Rampion Two Offshore Wind Farm

Appendix D/F2 to the Natural England Deadline 2 Submission
Natural England's Comments on [REP1-036], [REP1-012], [REP1-025] and
[REP1-030] in relation to Physical Processes and Benthic Ecology

20 March 2024

Natural England's Advice on the additional submissions relating to Marine/Coastal Physical Processes and Benthic Ecology

Figure 2-1 Marine Conservation Zones (MCZs) in relation to the Rampion 2 proposed DCO Order Limits

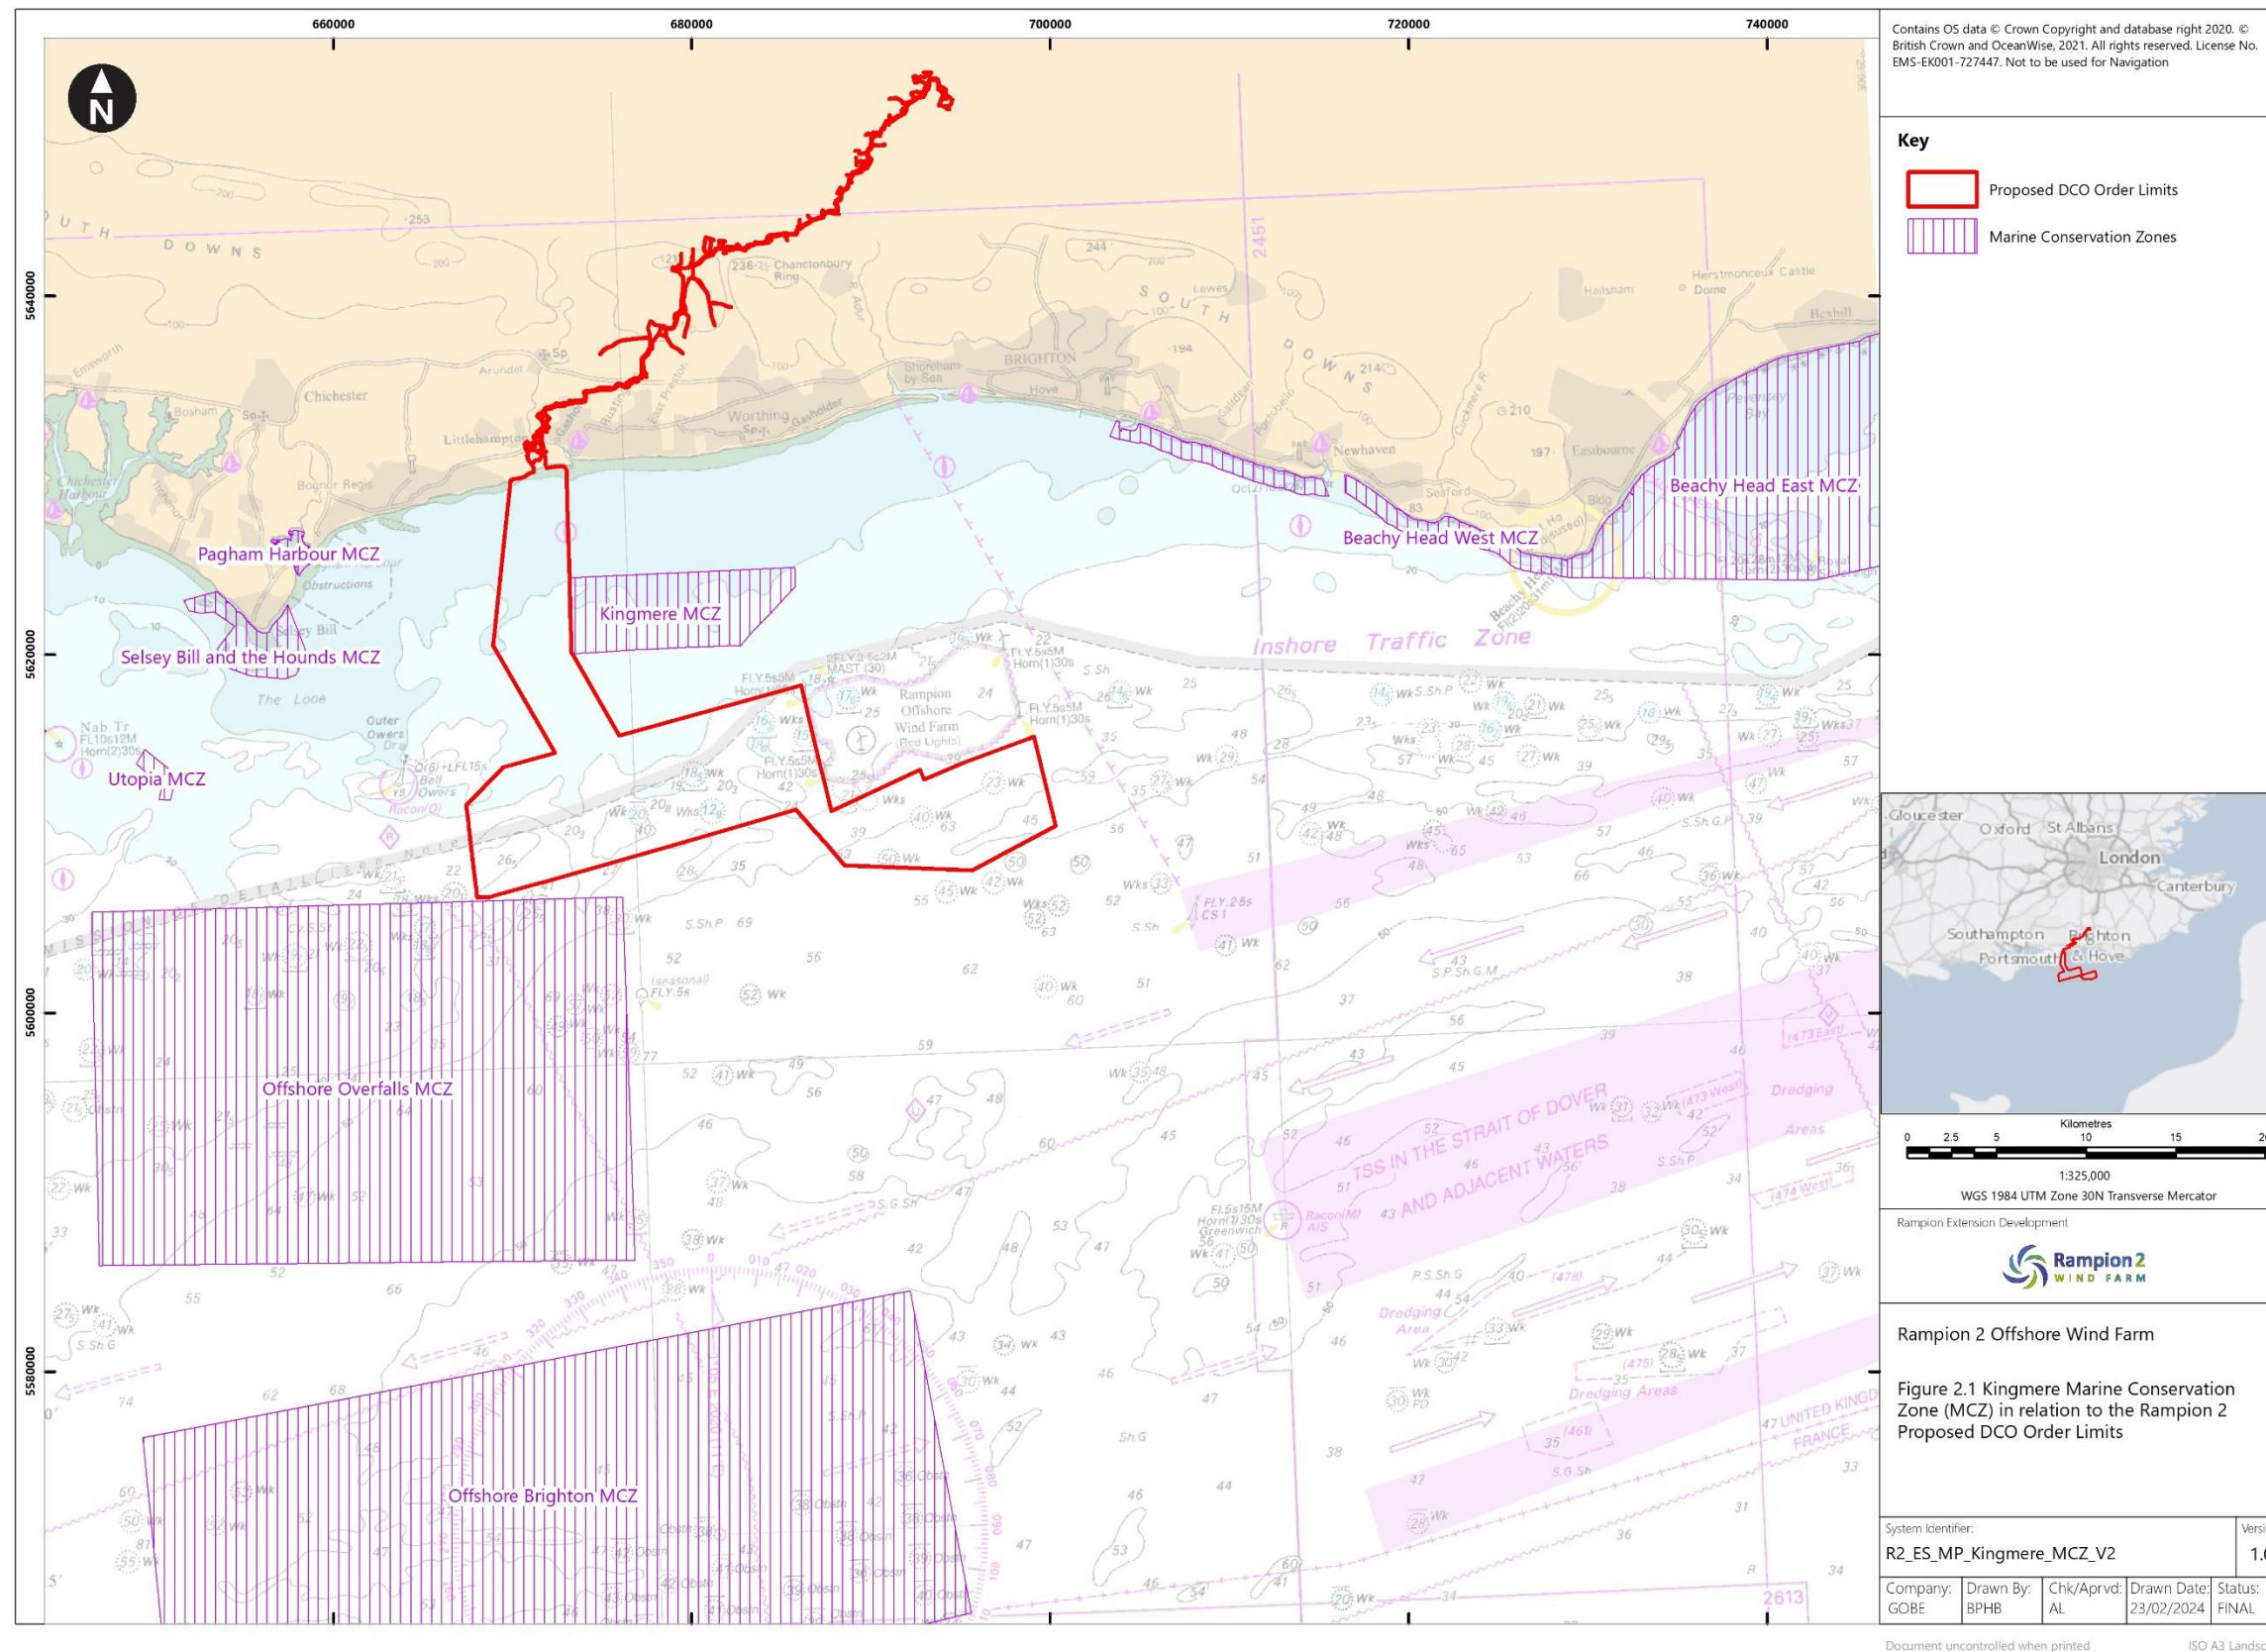
6. We note that there do not appear to be any tracked changes to 7.17 In Principle Sensitive Features Mitigation Plan, and the revision log suggested the changes are updates to Figures 2.1 and 5.1. As described in the Applicants Responses to Relevant Representations [REP1-017] the changes to Figure 5.1 involves increasing the resolution and the change to Figure 2.1 involves ensuring all MCZ's are shown. Therefore, aside from addressing our comment on Figure 2.1, our comments on this document remain the same as stated in our written/relevant representations. In future it would be helpful if both a clean and tracked change versions of named plans are provided so it is clear what has been changed.
